**From:** Seth Philbrook [SPhilbrook@tweed.nsw.gov.au]  
**Sent:** Tuesday, 17 February 2009 9:14 AM  
**To:** Jenny  
**Subject:** FW: Major Project Application No. 08\_0034 - Proposed Subdivision at Lots 2 and 3 DP 244652 Urliup Road Bilambil  
**Attachments:** image002.gif; Layout Option 2.pdf; 17397D.PDF; PHOTO-1.jpg; PHOTO-2.jpg; PHOTO-3.jpg; PHOTO-4.jpg; RE: (DWS Doc No 1942807) FW: Major Project Application No. MP08\_0034 - Bilambil Village

I have liaised with Council's Subdivision Engineer and Open Space Officer (in relation to your email dated 20 January 2009), to which the following comments have been provided;

PROPOSED SUBDIVISION PLAN

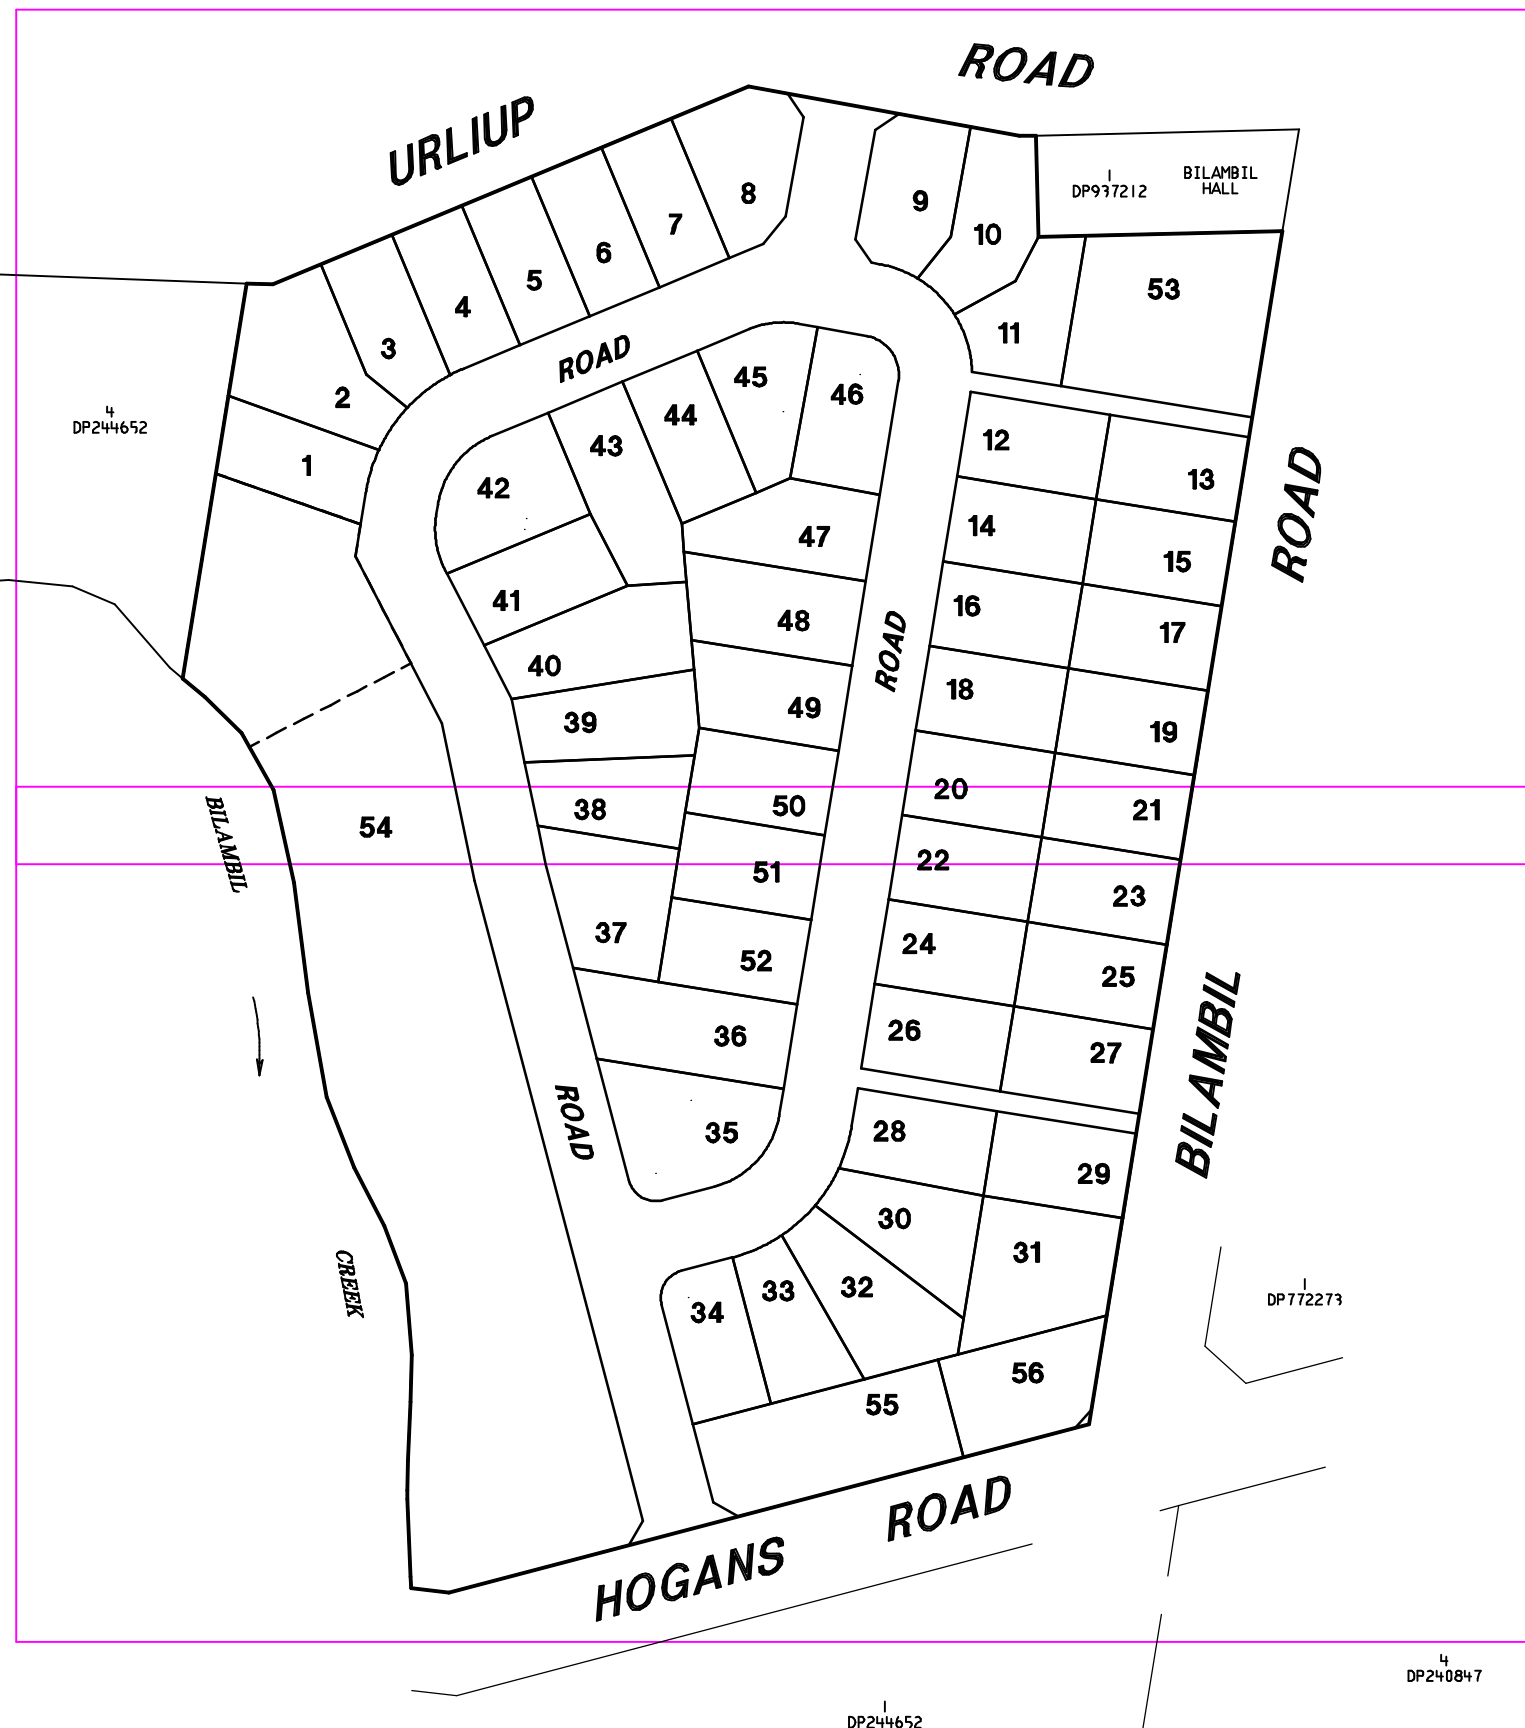
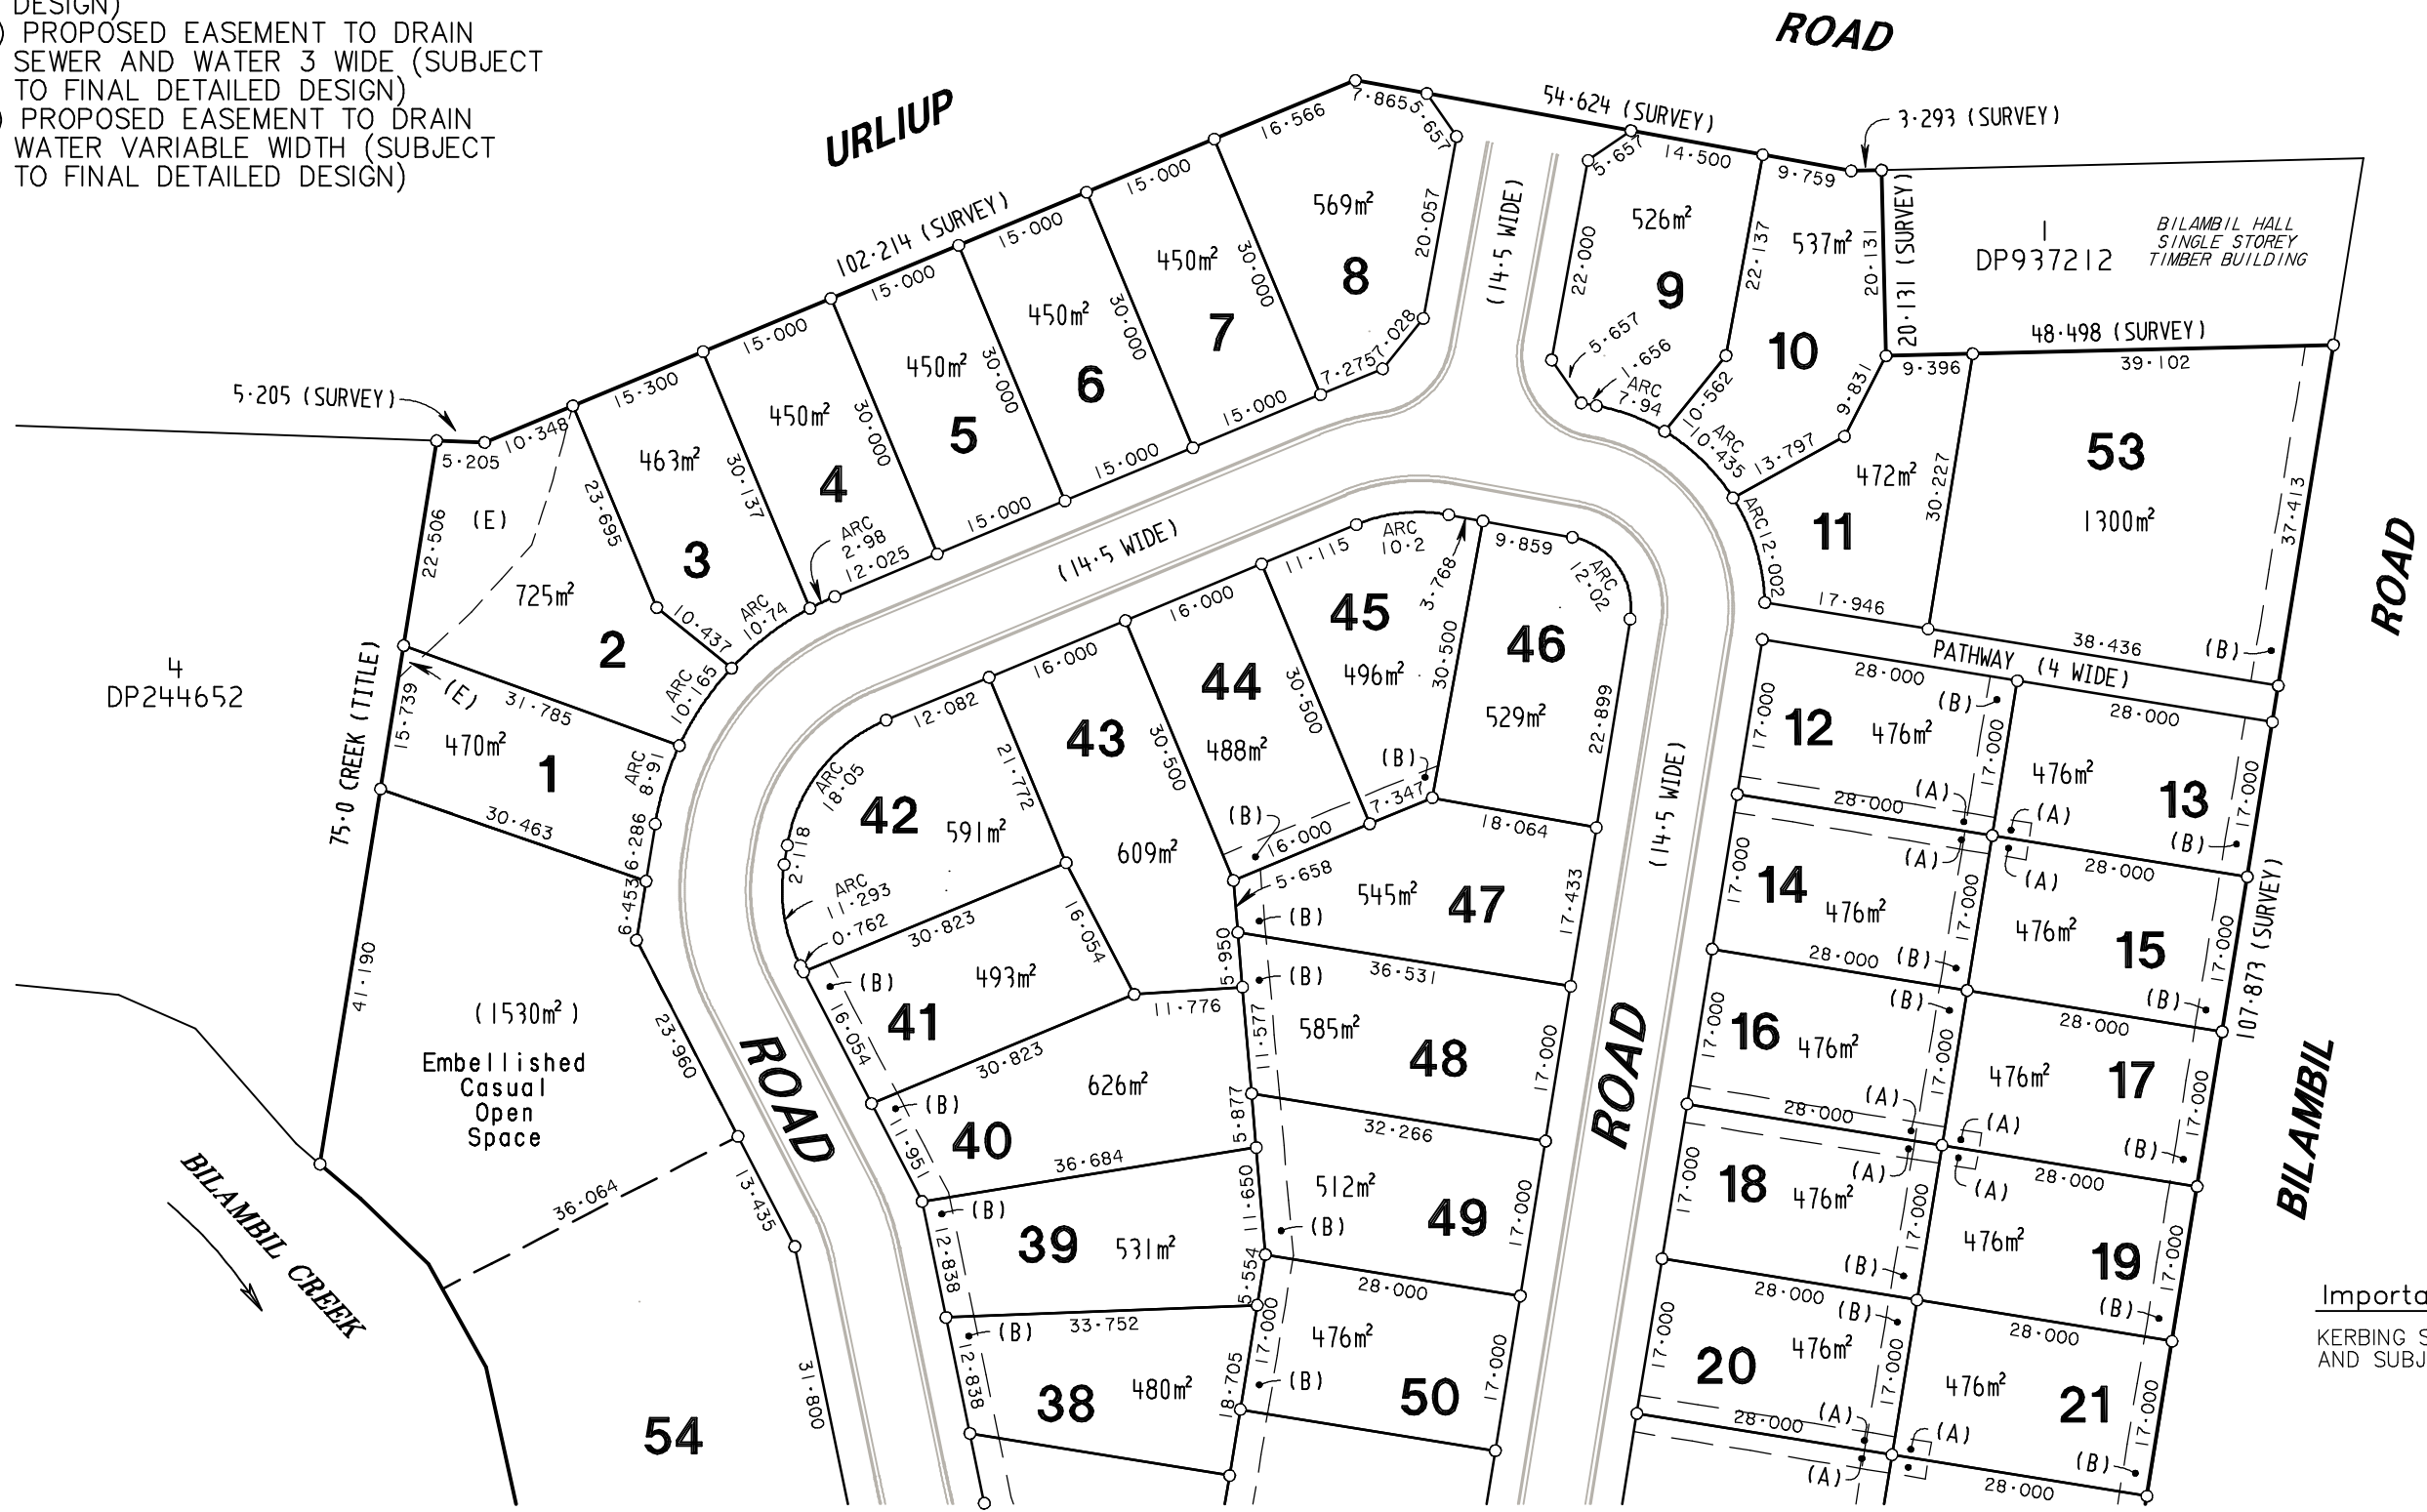
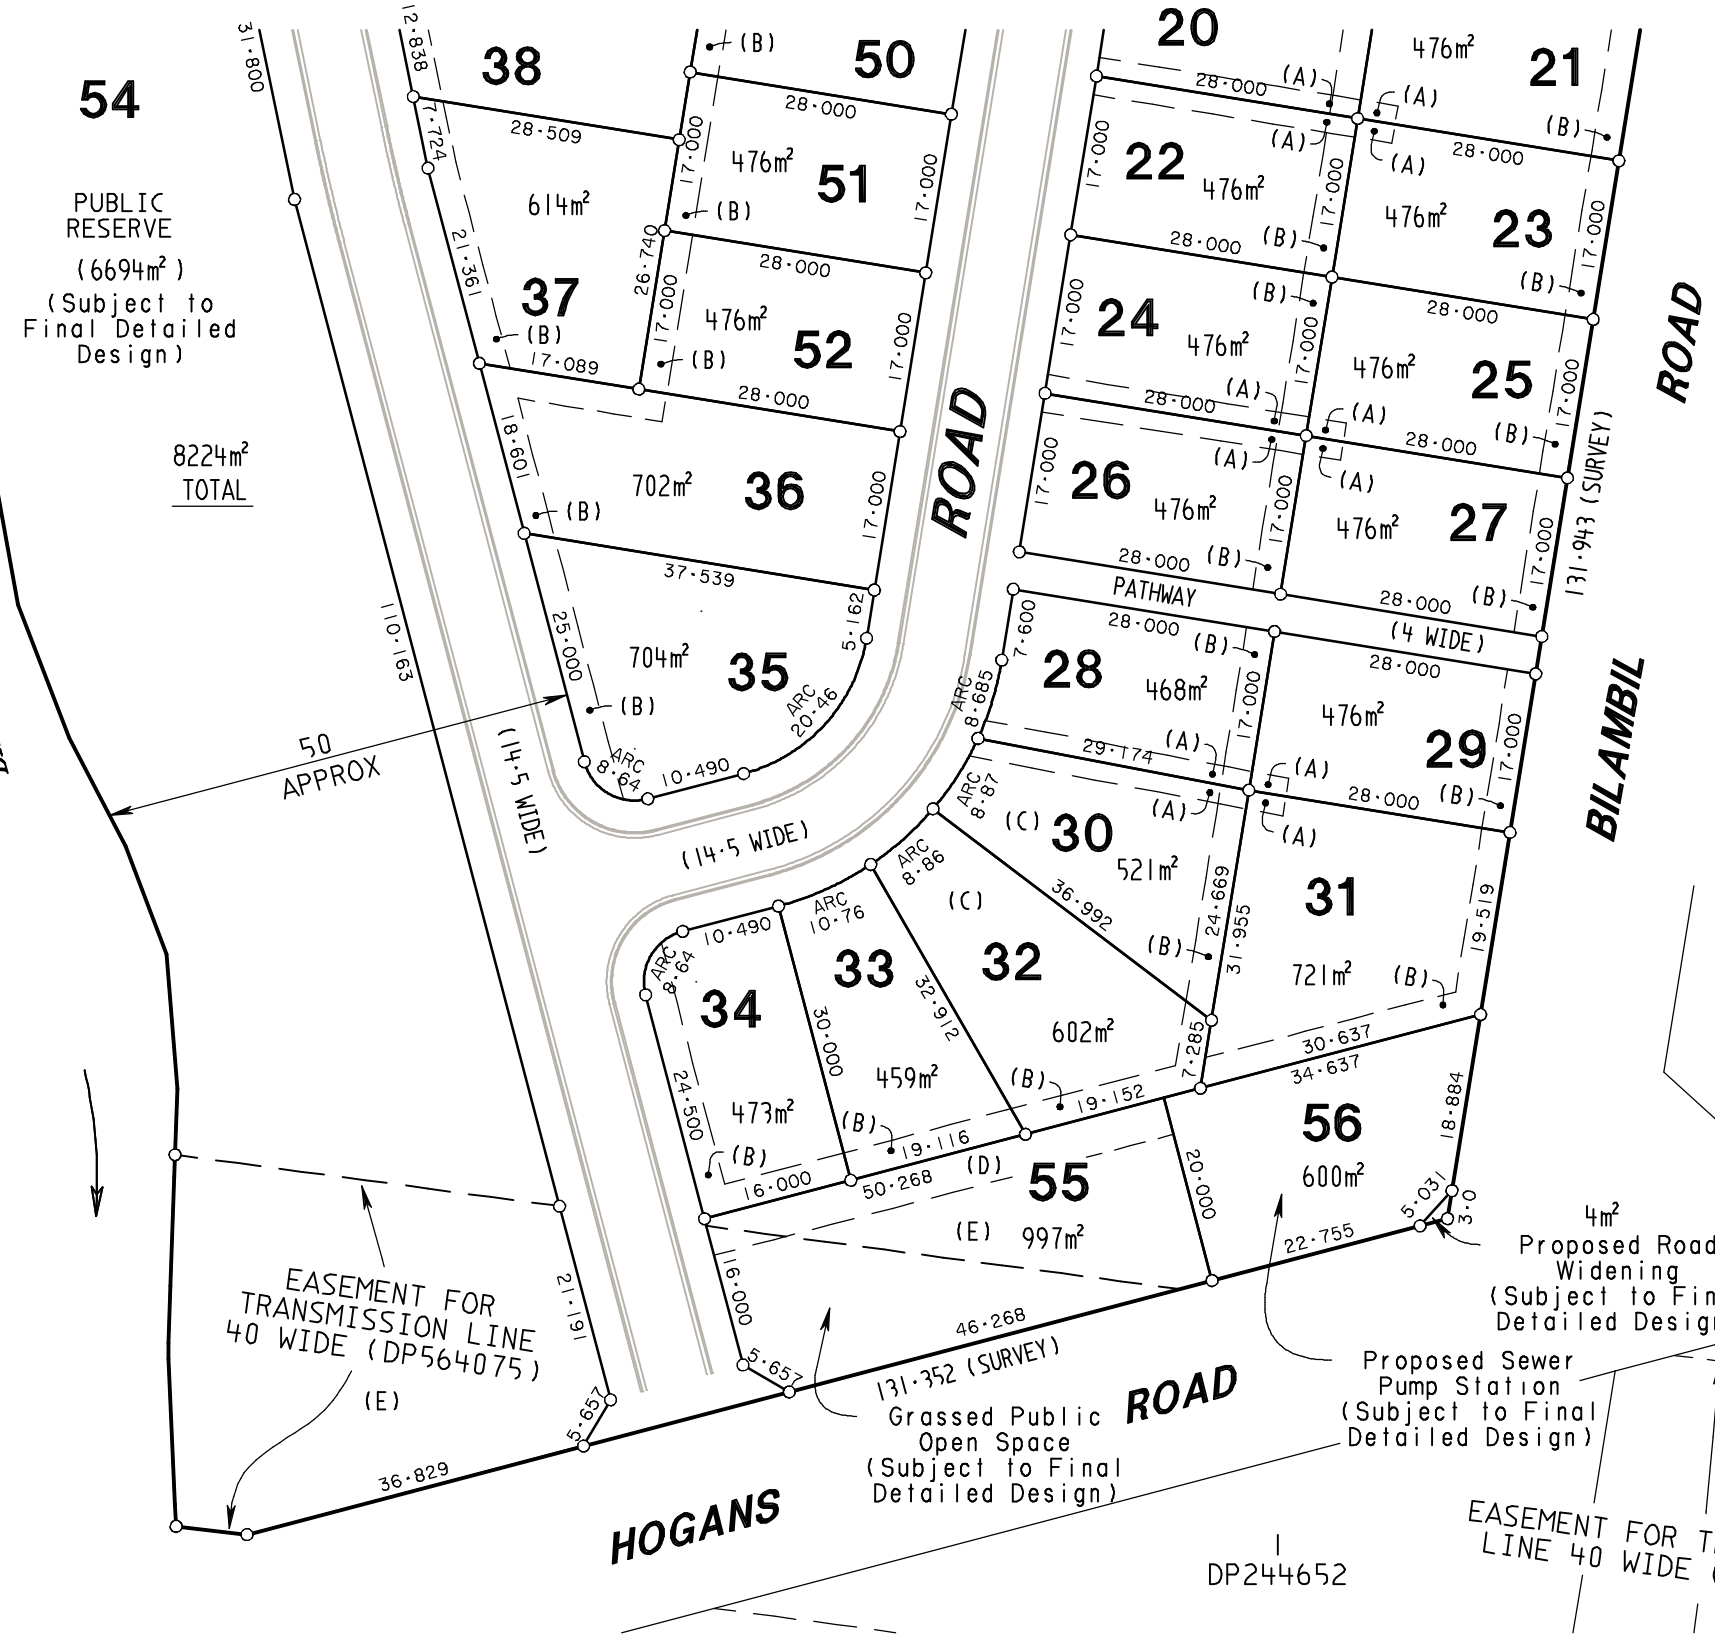
*The proposed roads and intersection layouts are not strictly in accordance with Council standards. However Council will accept the dedication of such infrastructure where provided in accordance with Council standards.*

*The provision of stormwater management devices located within the riparian buffer is not acceptable to Council.*

*The proposed open space is not accepted by Council. Council requires a minimum open space park in-accordance with sA5 of Council's DCP (min. 2, 500m<sup>2</sup>). Table A5-8.2.1.*
